Re: Marysville 172 Grading – *Tech Review 1*  
PA22012

RE: Marysville 172, File# PA22-012  
SEPA Application  
172<sup>nd</sup> Street NE & 23<sup>rd</sup> Ave NE, multiple parcels

TO: Chris Holland, Planning Manager  
FROM: Brooke Ensor, NPDES Coordinator  
DATE: 4/7/2022  
SUBJECT: PA22-012 Marysville 172 Grading

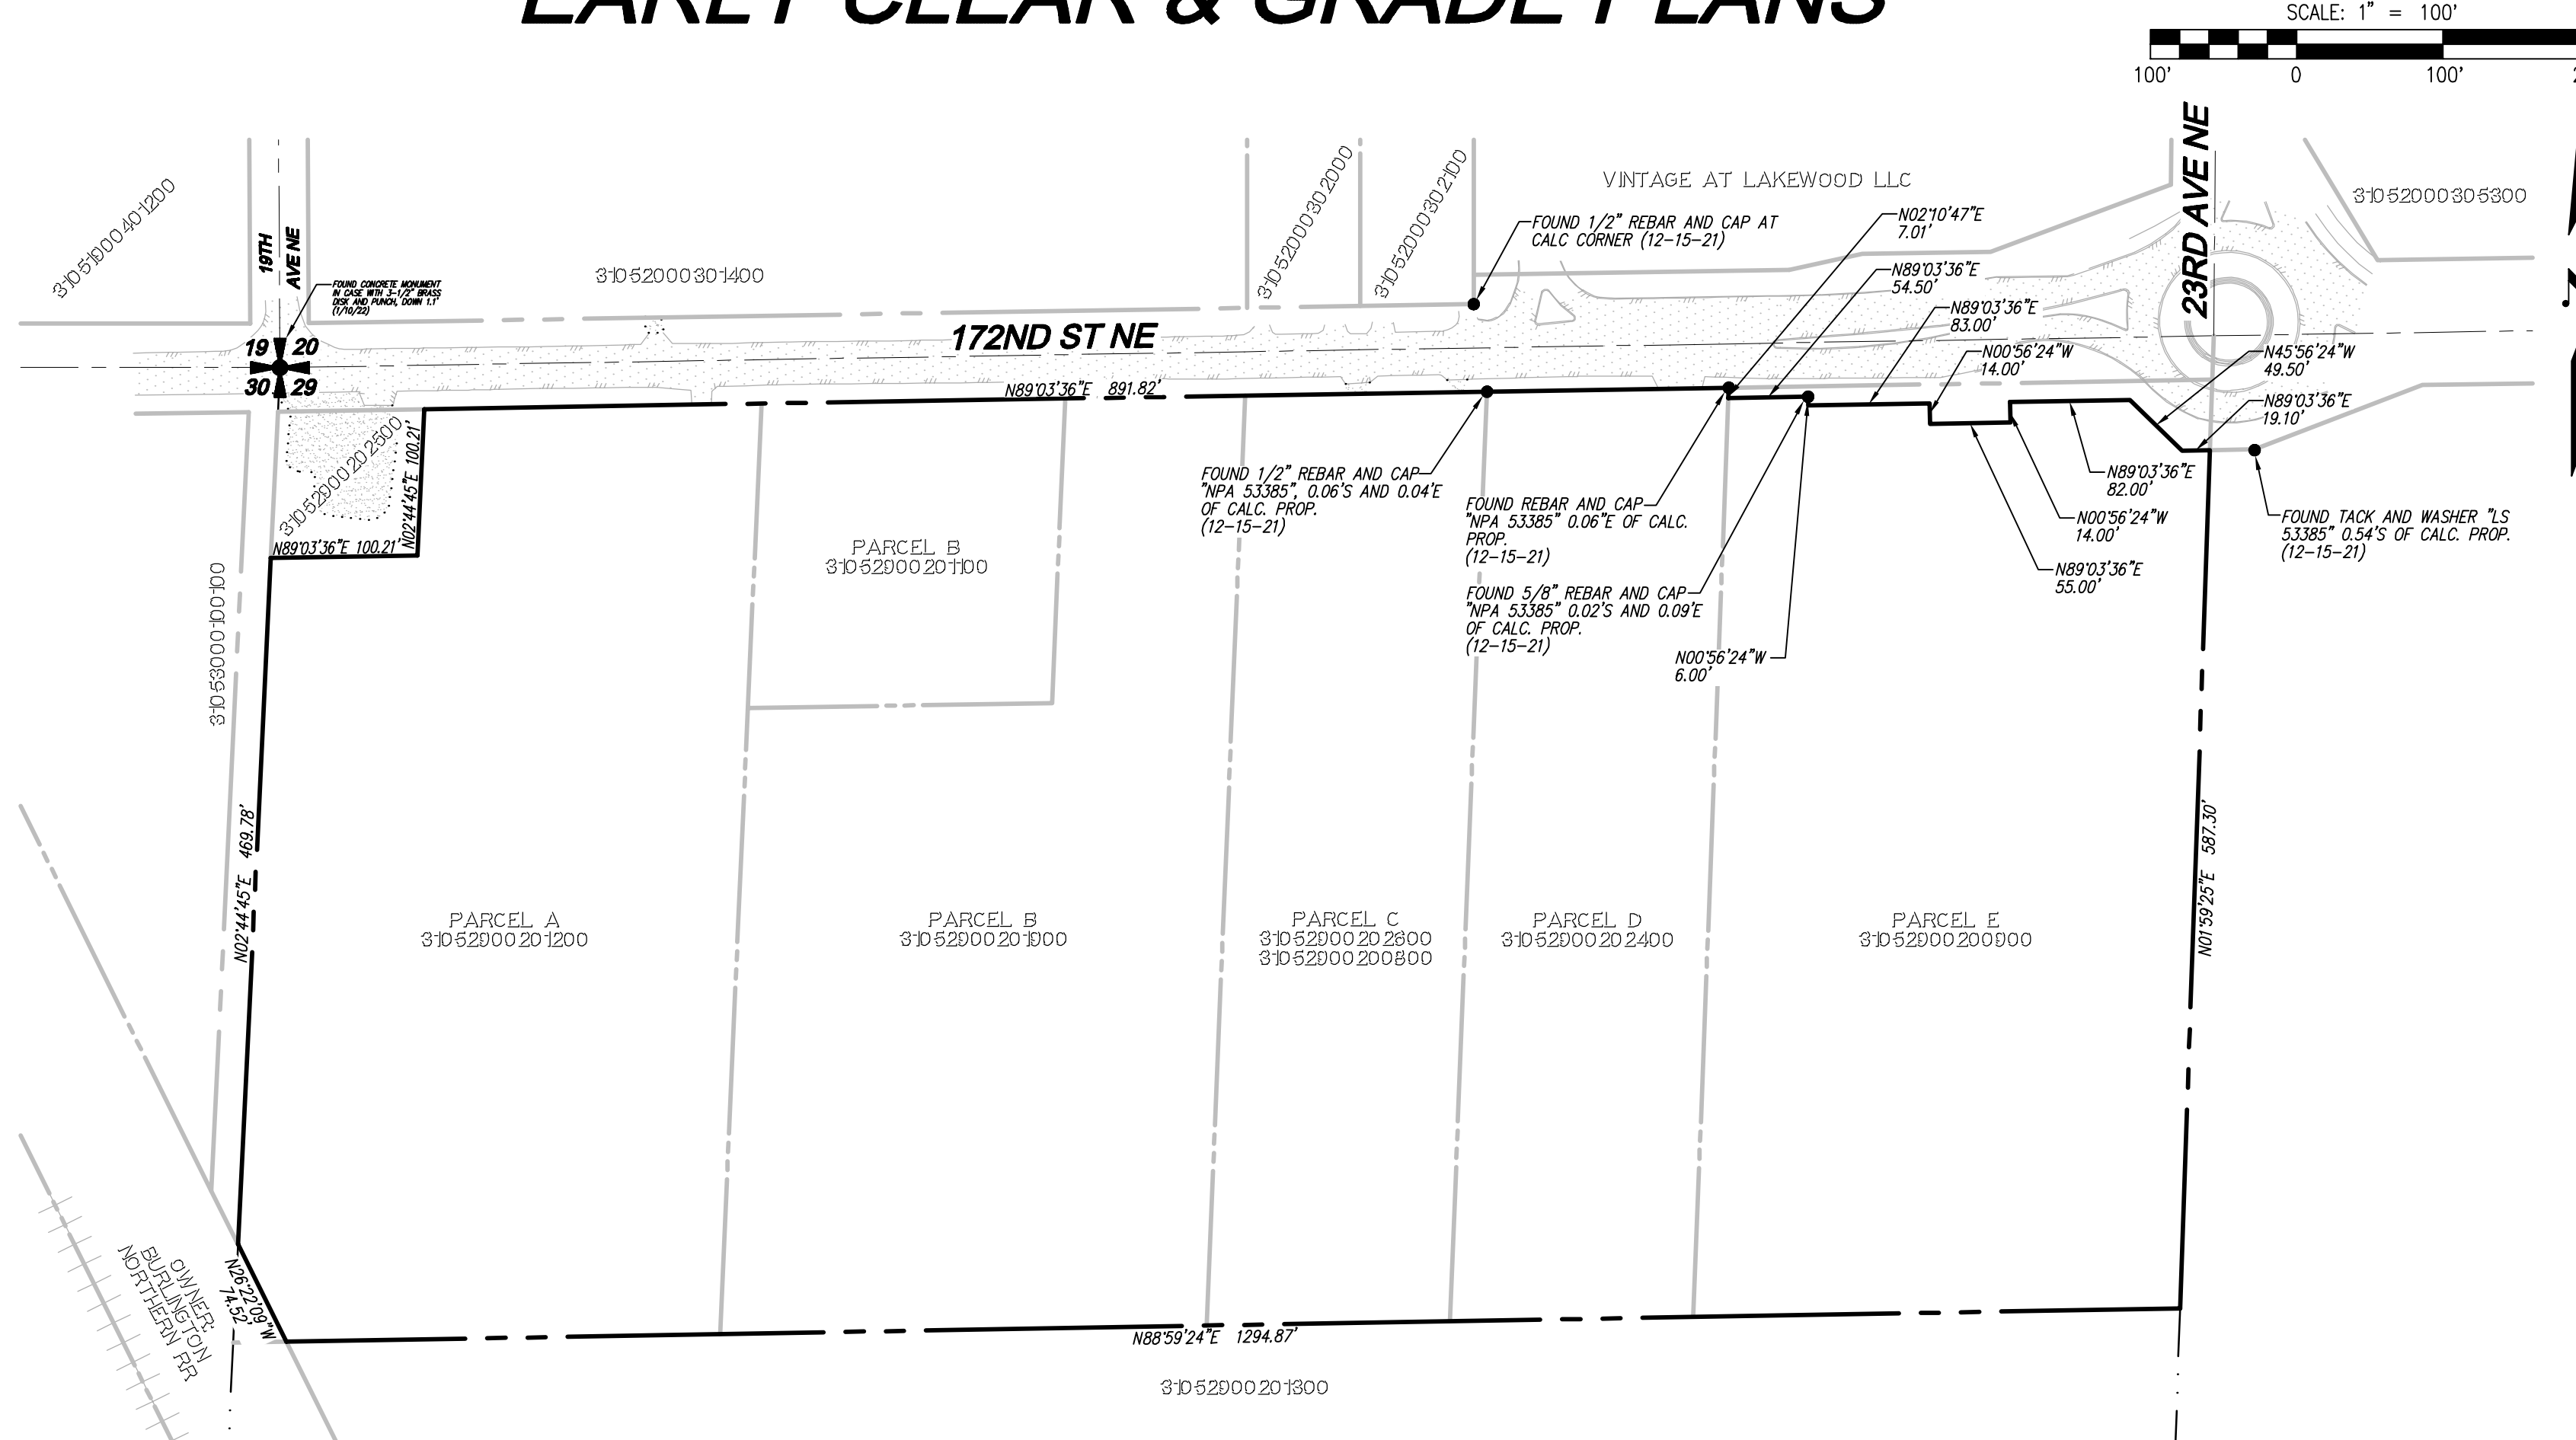
1. Provide File Number PA22012 on all future site, civil and landscape plan submittals.
2. Sheet TO-01 shall be amended to depict, or if unable to depict, reference the following encumbrances:

- a. APN 31052900201200:
    - i. Railway easement recorded under AFN 5850.
  - b. APNs 310592900201100 & 31052900201900:
    - i. City of Marysville easement recorded under AFN 1805320 (shown on adjacent property to east).

- c. APN 310592900202400:
    - i. City of Marysville easement recorded under AFN 1805322 (misabeled on sheet).
3. A SEPA Threshold Determination is anticipated to be issued the week of April 25, 2022. The following are DRAFT SEPA Conditions:

ER-01

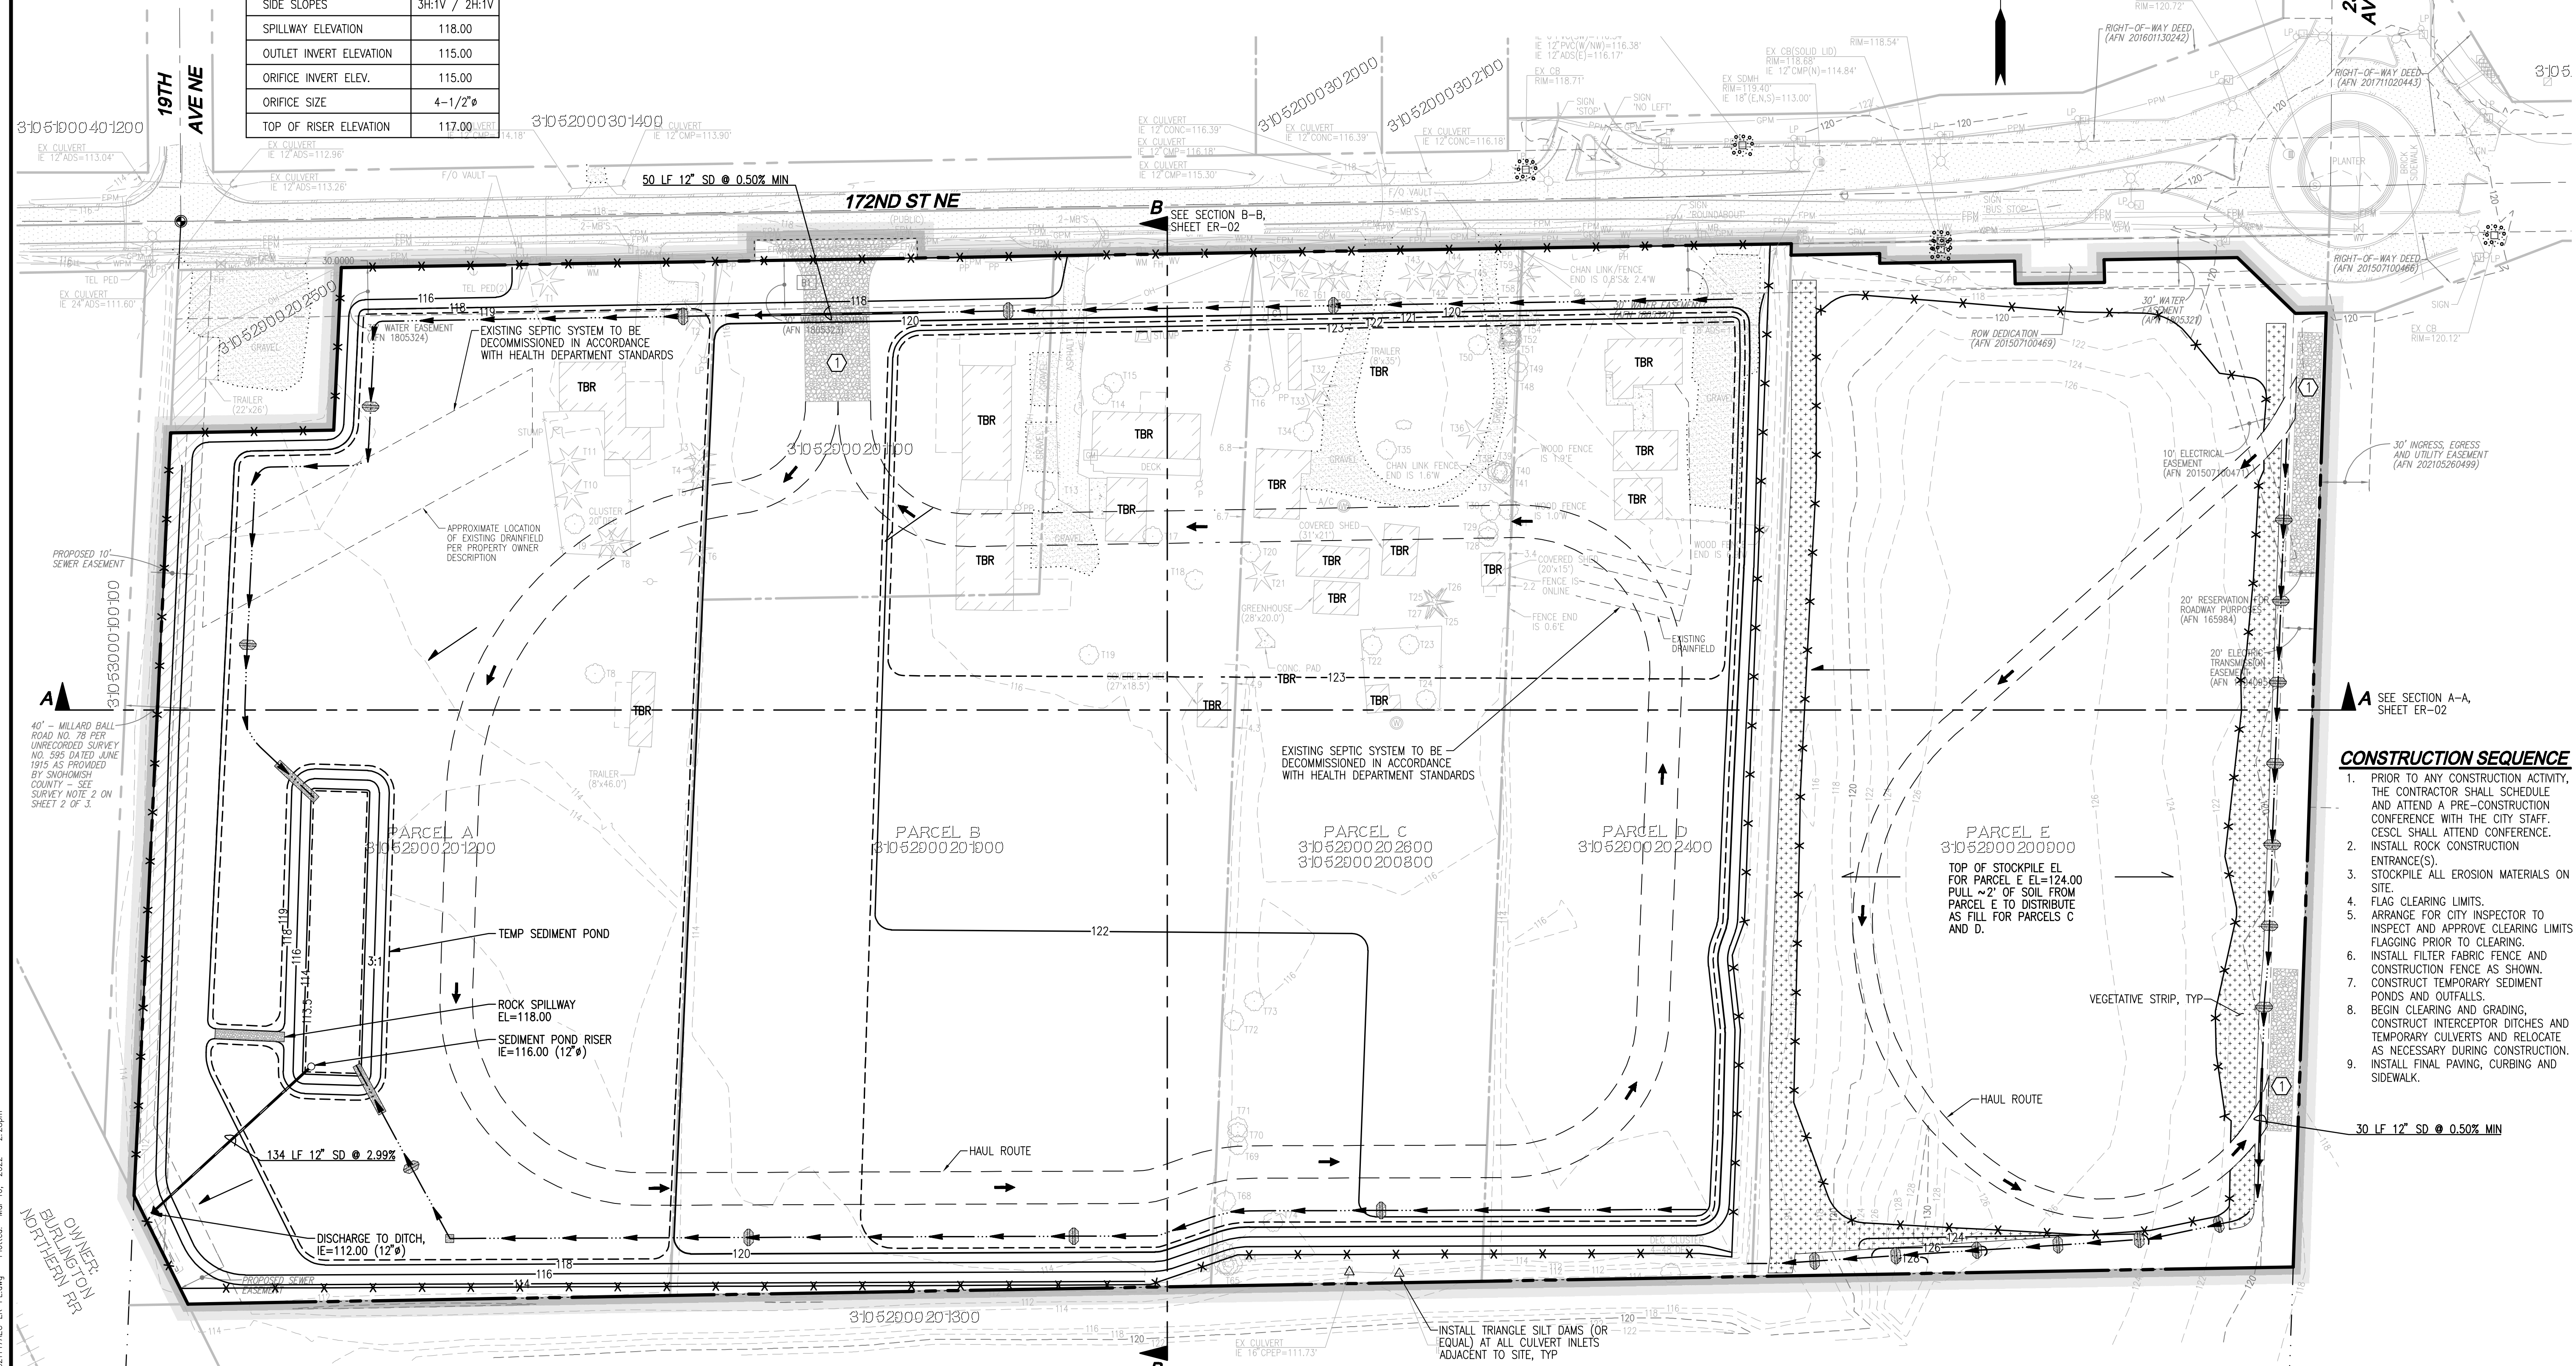
8. As an informational item, the project will need to obtain their NPDES permit prior to issuance of the grading permit.
9. ***The plans that have been submitted have been given a cursory review. A detailed review and comments will occur during the civil plan review phase. At this stage I would say to not have any grading occur within 5 feet of adjacent property lines.***

1. The City has adopted the 2012 Stormwater Management Manual for Western Washington, as amended in 2014 (2014 Manual), as our design standard
  - **Other long term grading projects in this area have caused excessive sedimentation in the City storm water system. Plan to implement additional BMPs (like a wheel wash), if grading continues through the winter. Sweepers have not provided adequate sediment control for the track out associated with this type of project.**
